# Rezoning Transportation Analysis

Petition Number: 2023-172

Date	Description
01-23-24	First Review (IW)
02-21-24	Second Review (KC)

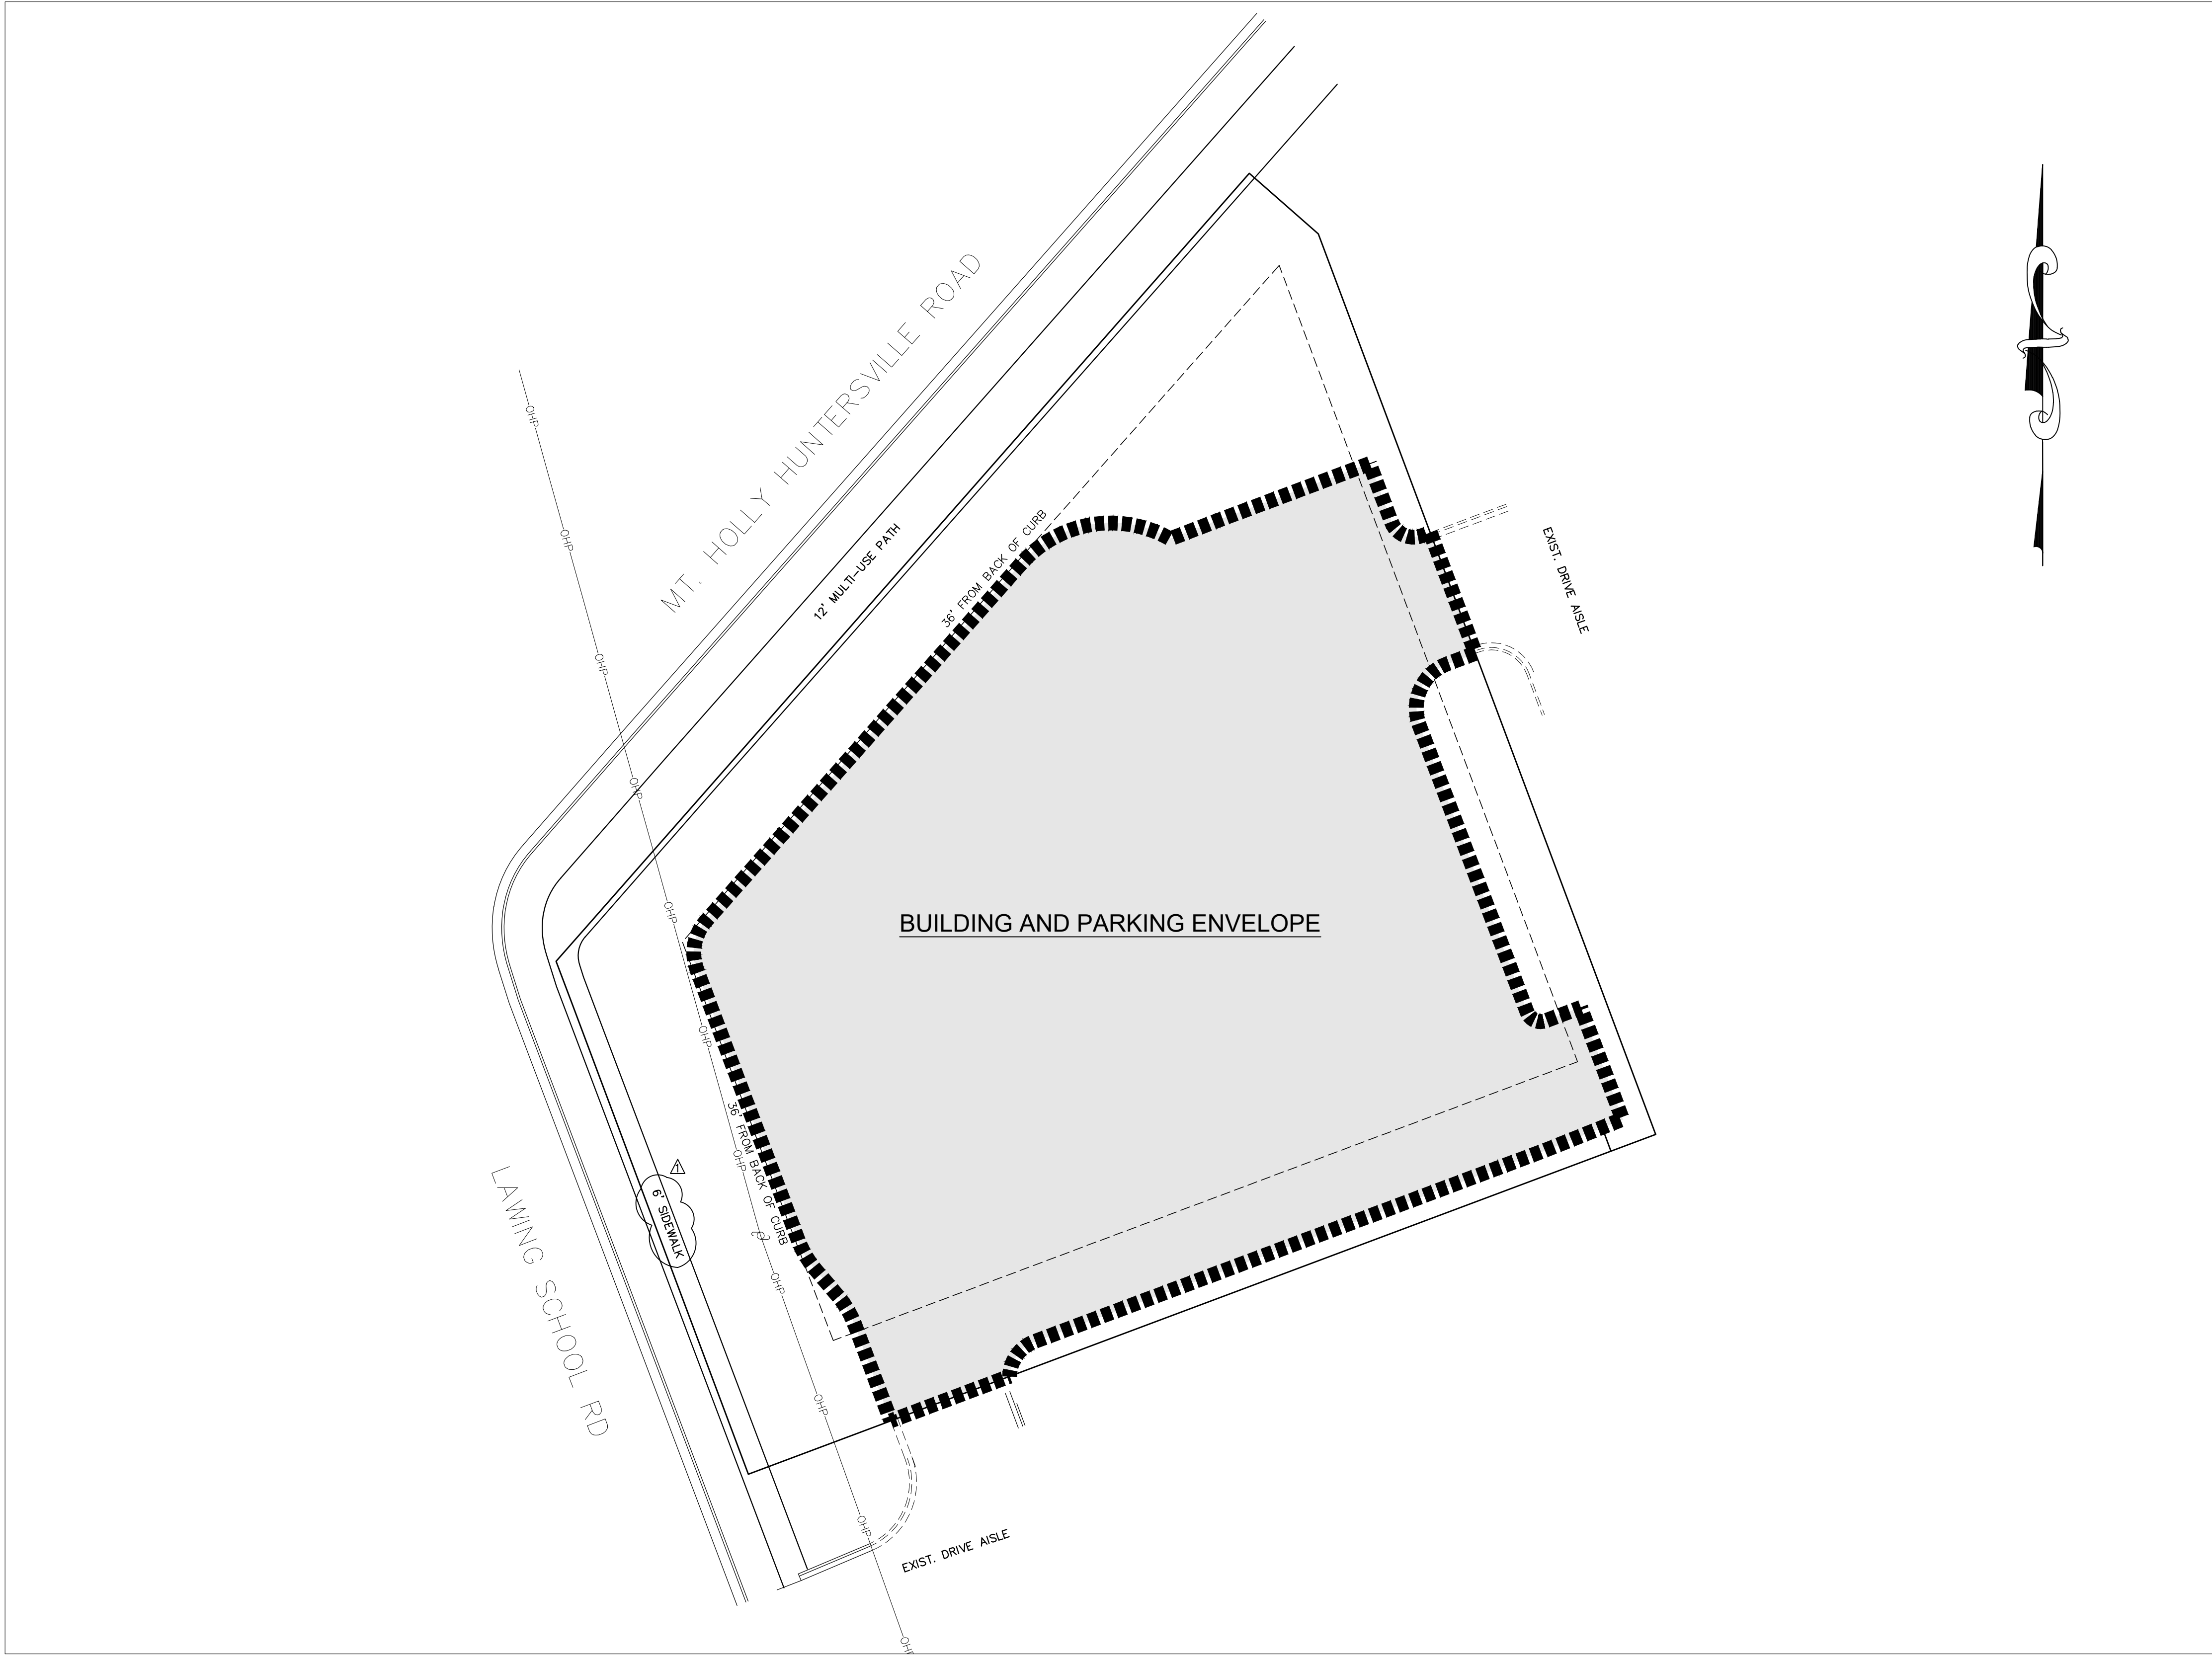
**1. ~~Curbline:~~**

a. ~~**Mt Holly Huntersville Road:** The future location of curb and gutter is 30' from centerline and appears to be in its existing location.~~

~~4+ Avenue, Shared Use Path per the Charlotte Streets Map~~

b. ~~**Lawing School Road (Spell it out):** The future location of curb and gutter is in its existing location.~~

~~CLDSM standard Local Collector Street U-07B~~

~~Label and dimension the curb and gutter from the centerline for each road on the site plan.~~

- ~~3. Revise site plan and conditional note(s) to commit to dedicate 50 feet of right of way from the Mt. Holly Huntersville road centerline. The site plan shall label and dimension the right of way from the road centerline.~~

- ~~4. Revise site plan and conditional note(s) to commit to dedicate 33.5 feet of right of way from the Lawing School road centerline. The site plan shall label and dimension the right of way from the road centerline.~~

- ~~6. Revise site plan and conditional note(s) to commit to cross access at south eastern portion of site along Lawing School Road to align with Article 31 in the UDO. It appears the site may be committing by layout on site plan. CDOT would like to see labeling and/or language stating this will specifically be set up for cross access.~~

7. ~~Revise site plan and conditional note 5.c. to specify which sidewalk the site is committing to constructing. The site plan shows a 12' MUP but the note references the Local Collector Street, which is actually CLDSM U-07B not a local narrow street. The sidewalk would be required to be 8'. Please update and specify which sidewalk width the site plan will be committing to.~~
